Re. Planning Application AW/337/19/A

We are objecting to this application as the proposed signage is too big, too bright and out of keeping with the area of Special Character. The colours of the signage are in direct conflict with Policy HERSP1, which states that, locally listed heritage assets, ie, buildings or structures of character, will need to be conserved and enhanced in a manner appropriate to their significance and contribution to the historic environment. Furthermore, we think the window dressings are also detrimental to this Area of Special Character.

PROPOSED SITE SIGNAGE

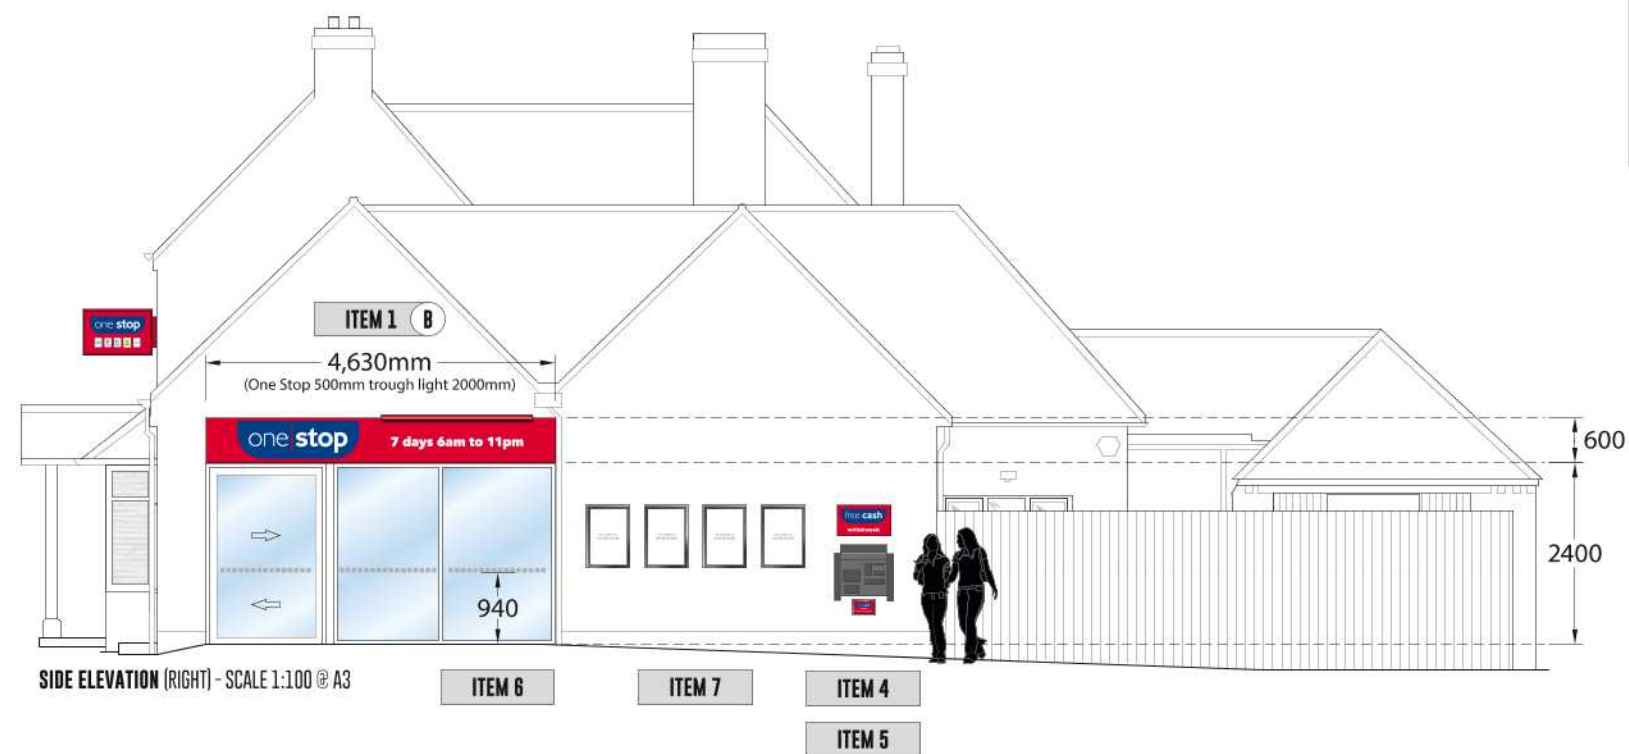
The sign over the eastern entrance, will be 'through illuminated'. This sign is inappropriately large and light polluting. The sign on the western elevation will be 'through illuminated' and therefore clearly visible far down Aldwick Street to the east & west.

The sign on the front of the building facing south, will be 2.9m long by 0.6 metres. This is completely out of proportion with the signs of other businesses in the opposite parade of shops and will dominate the street. The bright red, white & blue projected sign facing West and East, which will be internally illuminated, will also be a light polluting eyesore.
